Your comment

First, the proposed access road from the A635:

HGV ROUTING PLAN

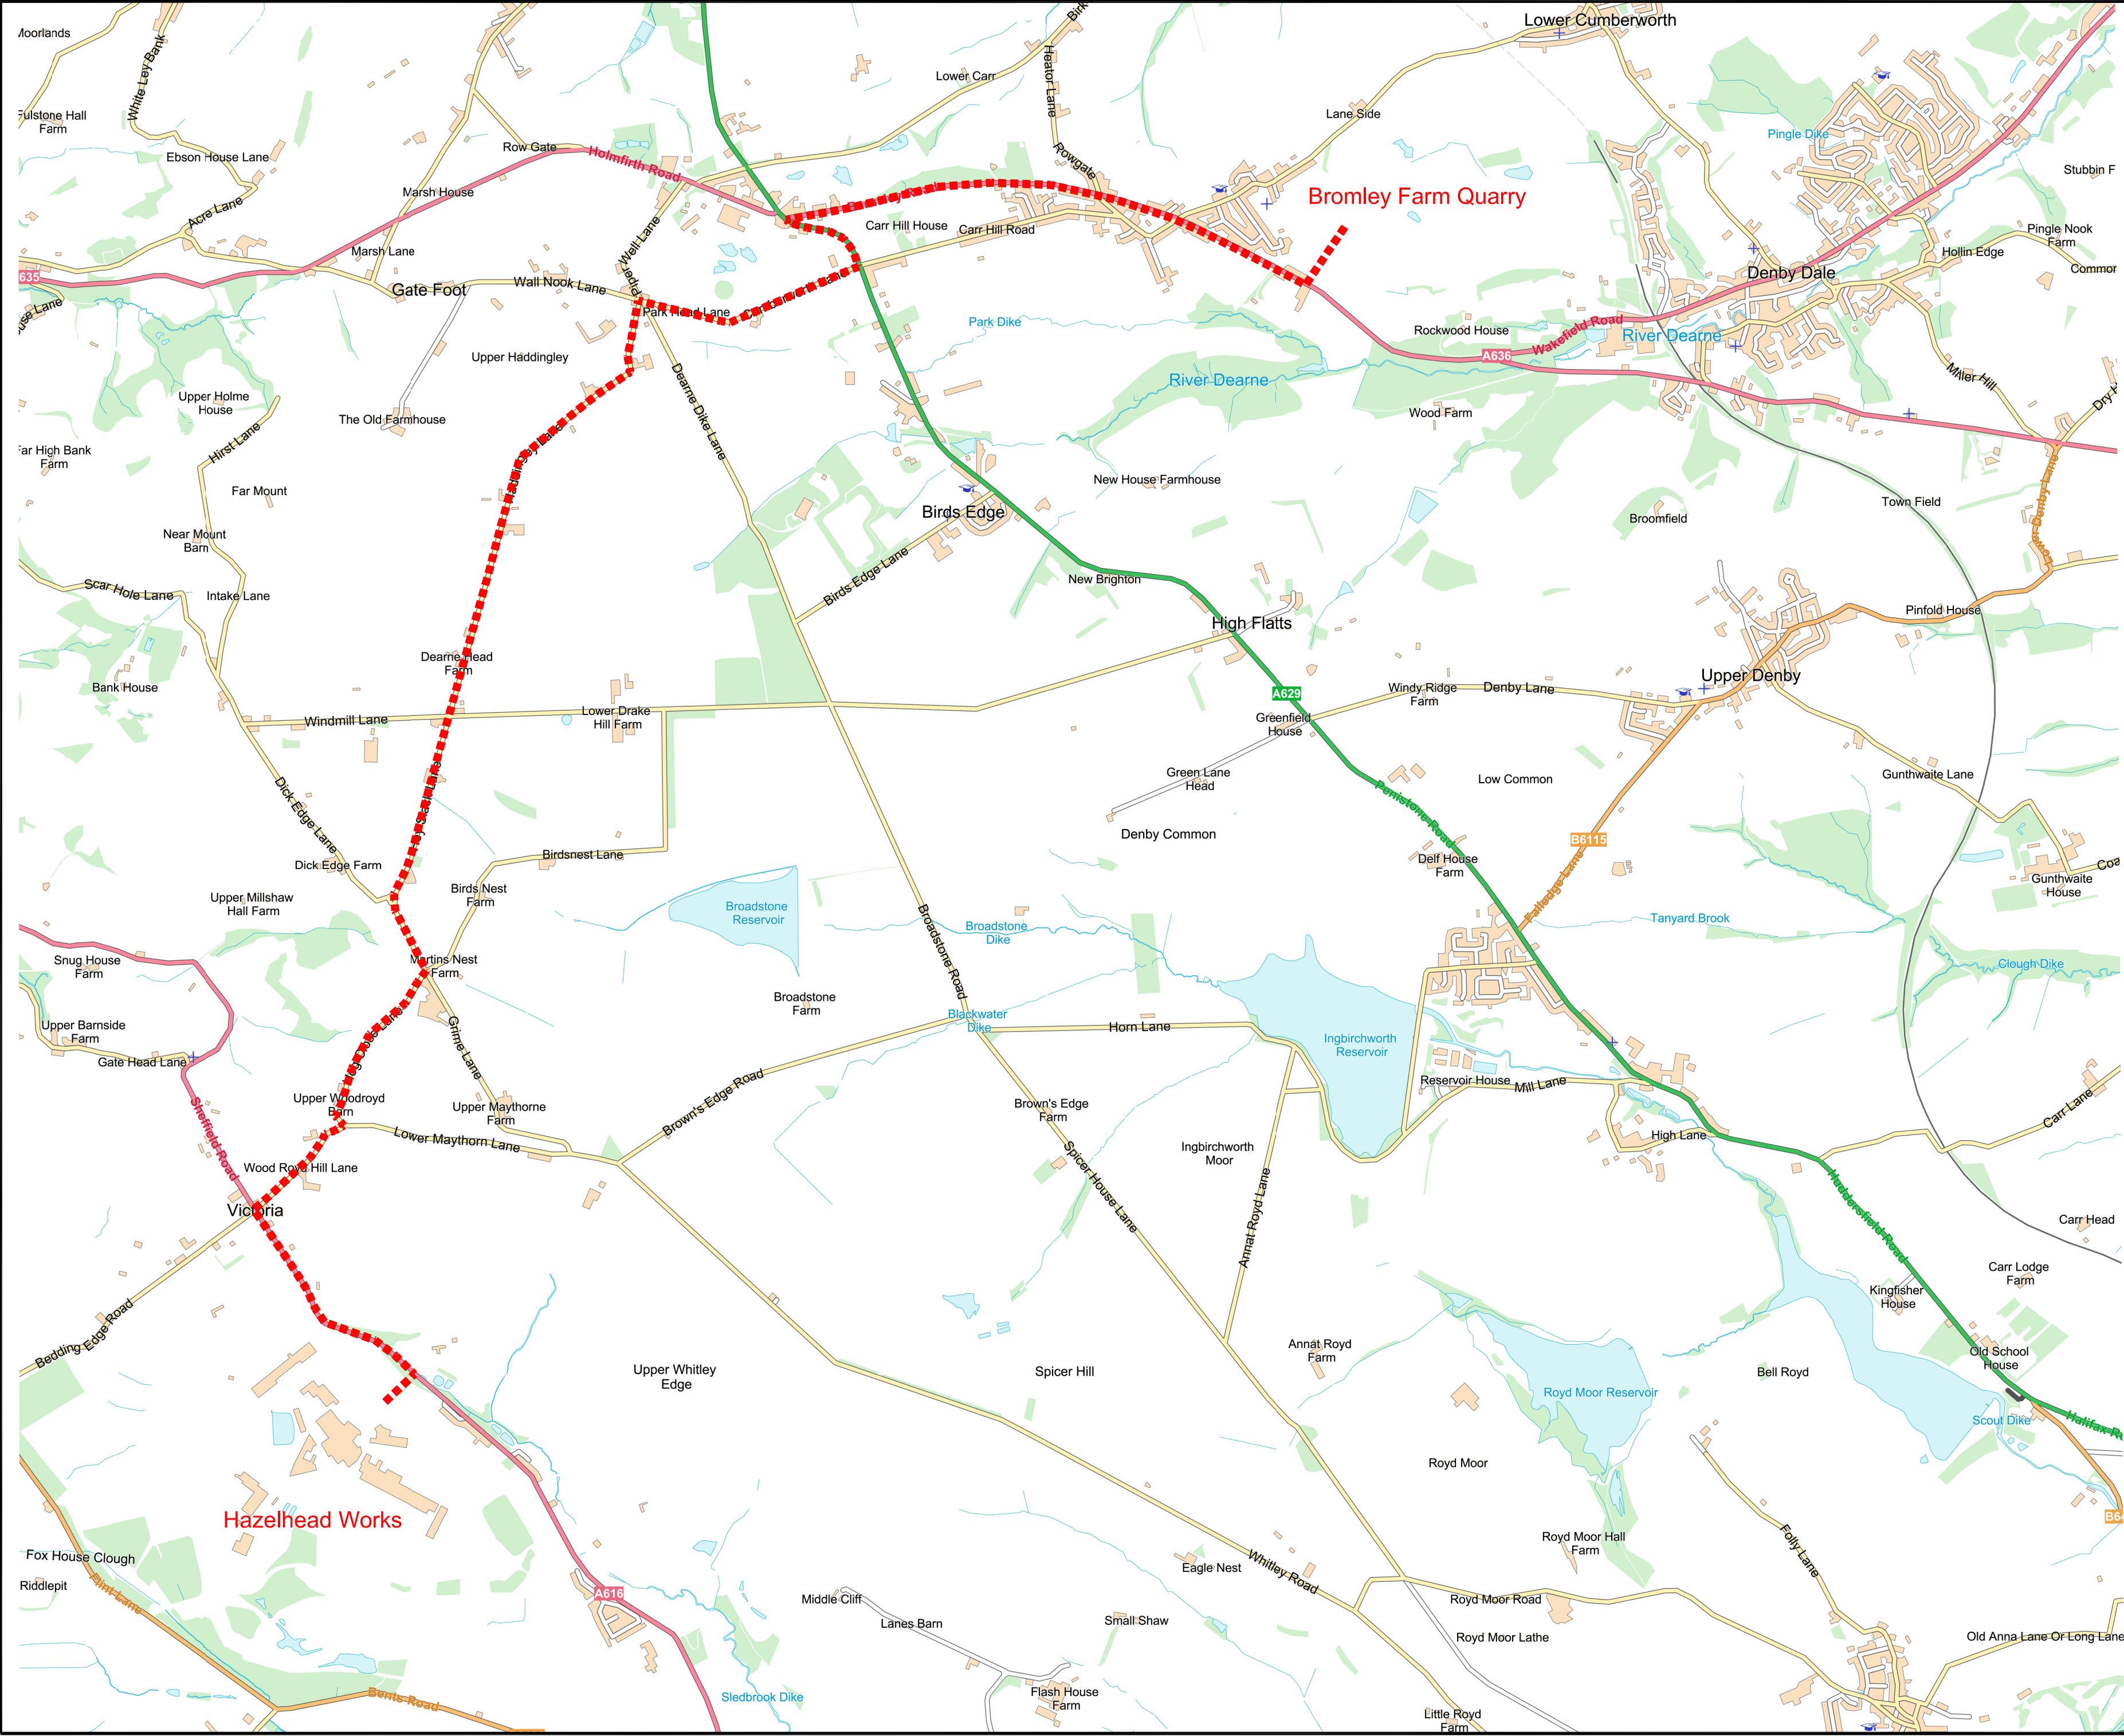
This narrow road is already heavily used by traffic to the recycling centre. It is too narrow for a car and HGV to pass each other. This means that an HGV coming down Barnsley Road could not move onto the access road if a car/cars were waiting to exit it - a very regular occurrence. Similarly cars coming up or down the A635 could not turn onto the access road if an HGV were waiting to come out. The tailbacks caused would be chaotic and dangerous & would increase pollution from vehicle emissions and noise.

**Access surfacing**
300 mm depth of ST4 concrete (brushed surface)
with double reinforced A394 mesh

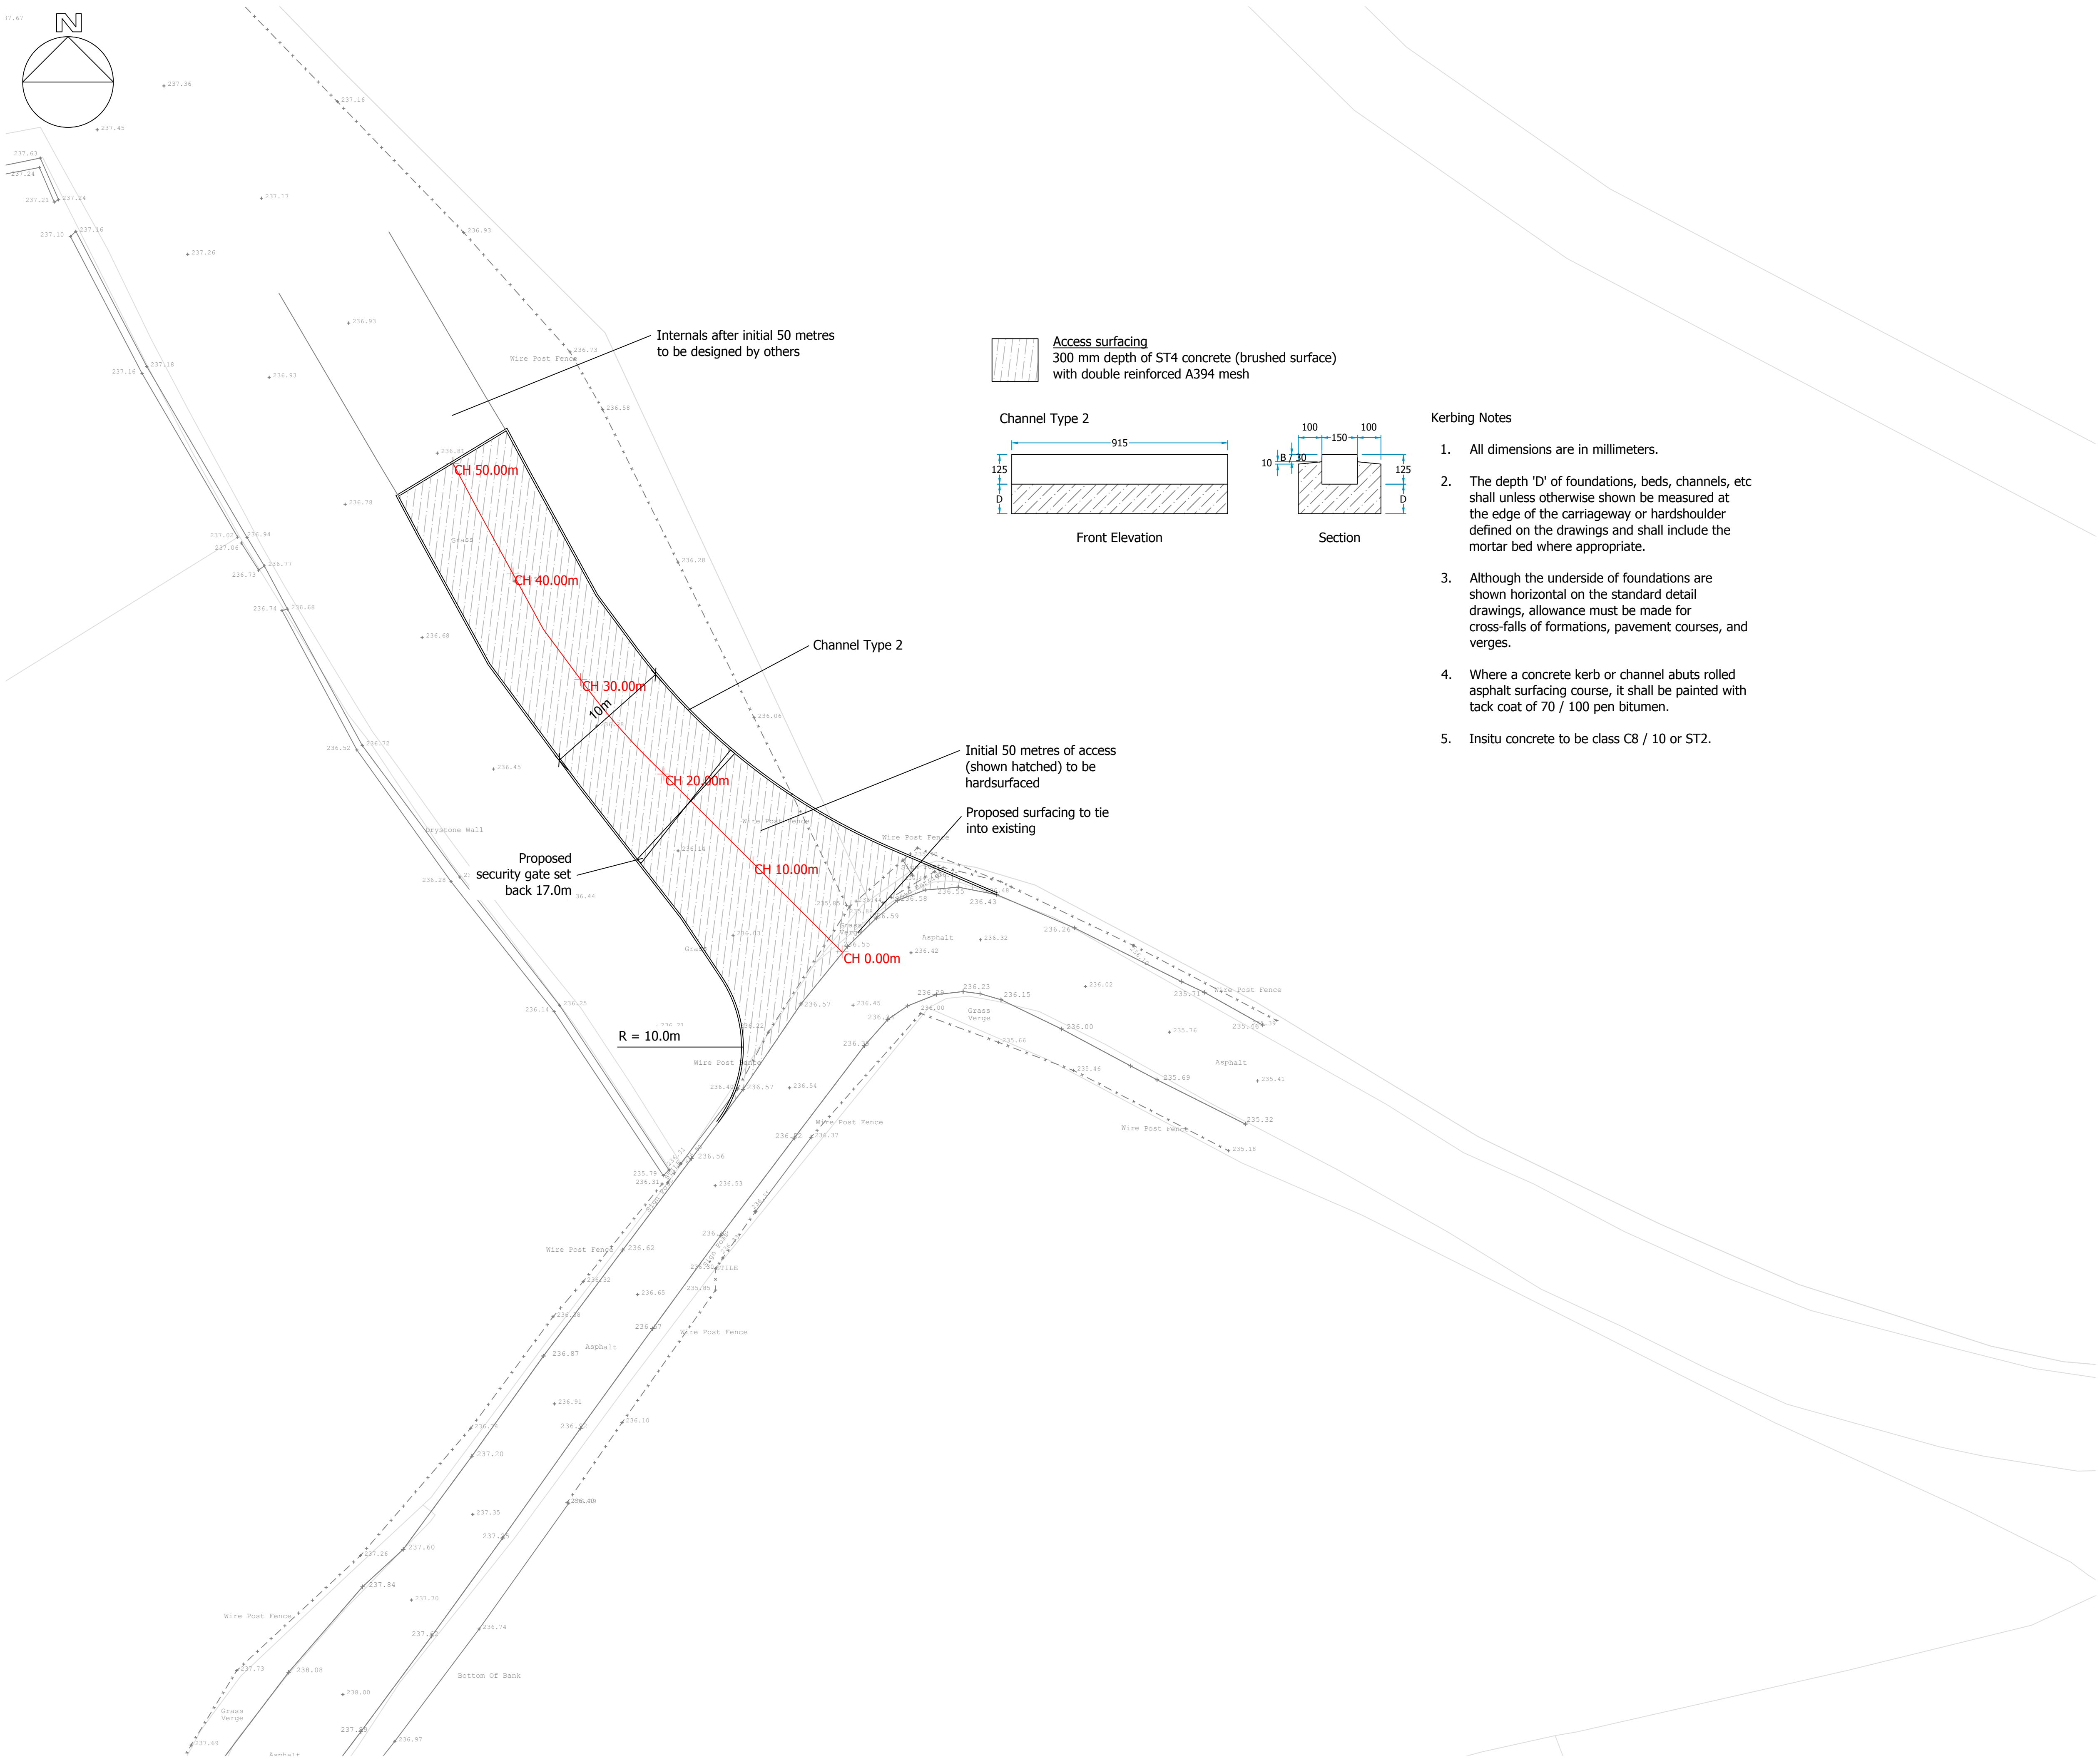
This PRow is used by four of the walk-trails devised by Denby Dale Walkers are Welcome group - the Denby Dale to Shepley Trail; the Denby & Cumberworth Circular; the Denby Dale Round Walk; & the HonDenTrail, linking Honley & Denby Dale stations on the nearby scenic Penistone Line.
